FALCON MEADOWS AT BENT GRASS DRAINAGE CHANNEL

CONSTRUCTION DRAWINGS (PLAN & PROFILE)

Engineering Review
 10/31/2021 5:23:36 PM
 dsdrice
 JeffRice@elpasoco.com
 (719) 520-7877
 EPC Planning & Community
 Development Department

CDR XX-XXX CDR2114

C0.0

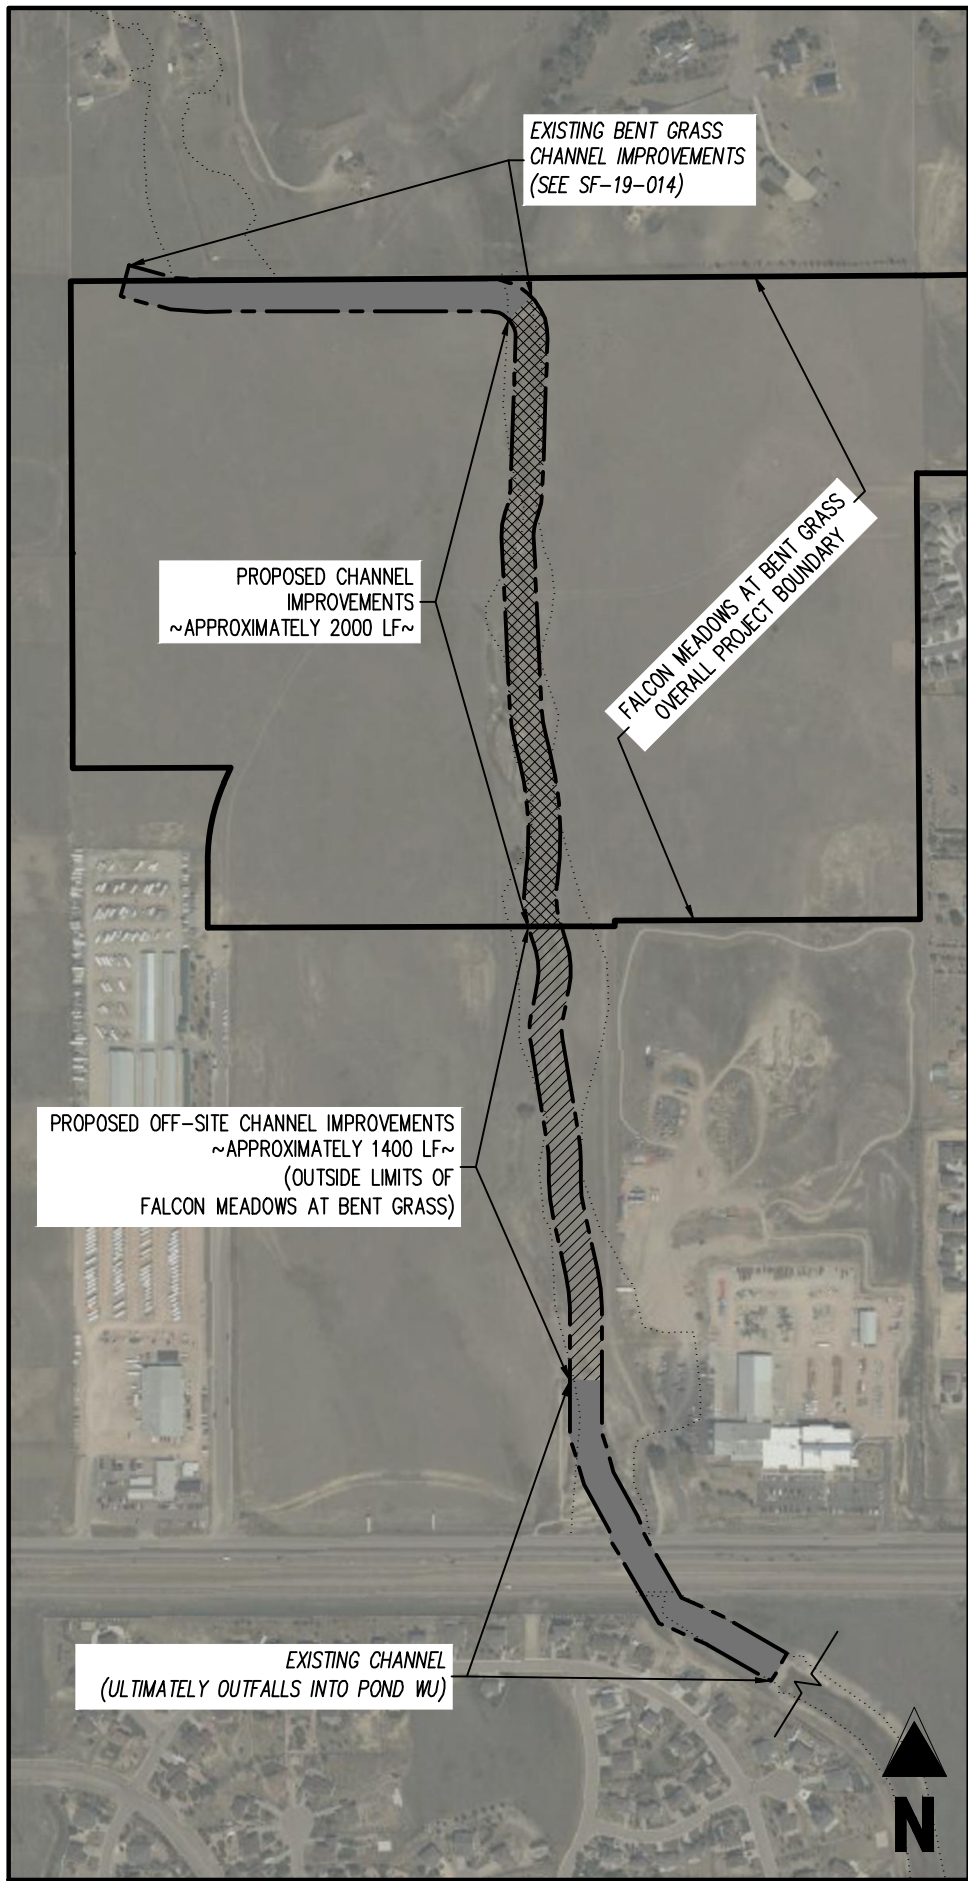
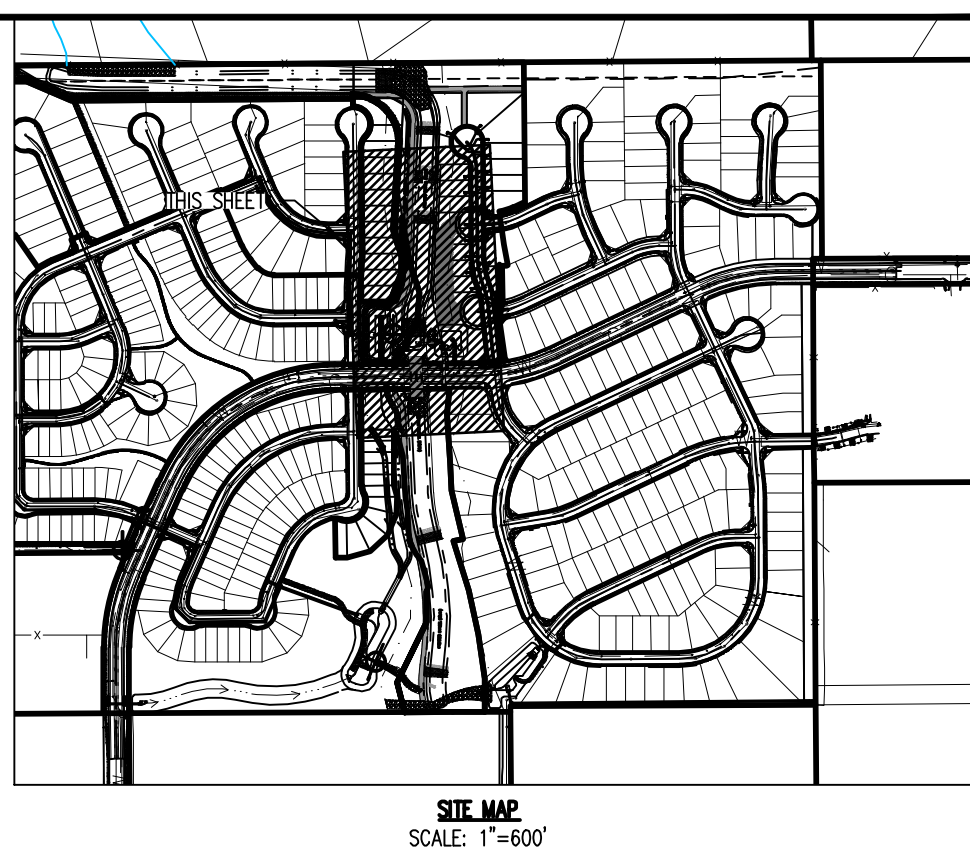
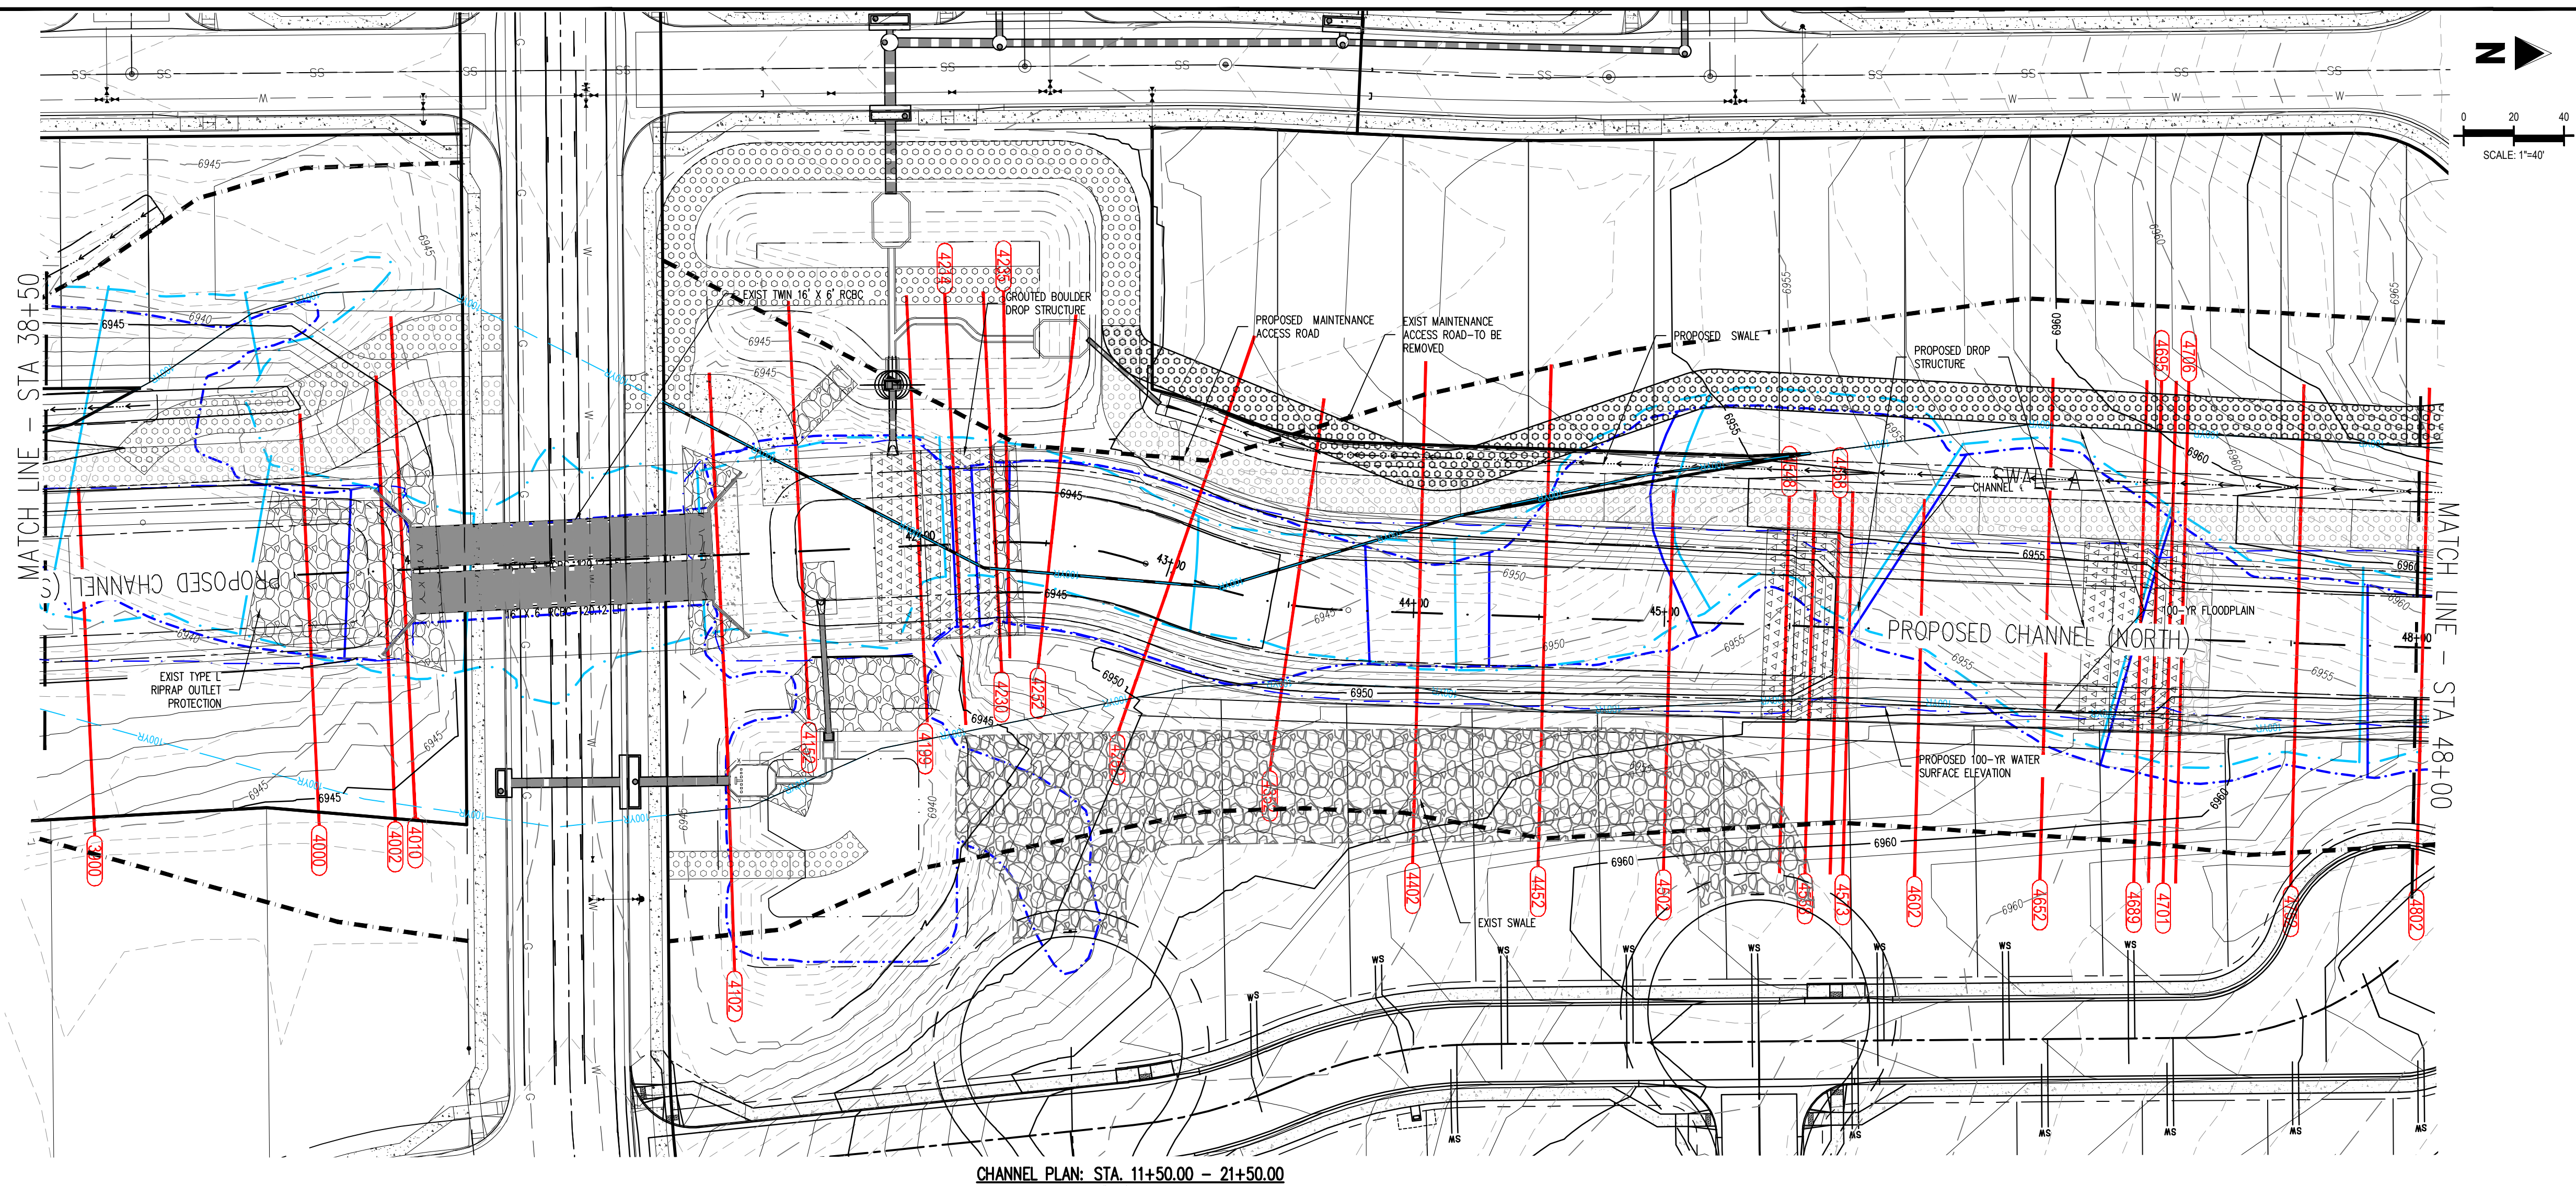
Provide sheet index

Are you going to separate the segment north of Bent Grass Meadows Drive?

fix sheet #'s, there's only 4 sheets.
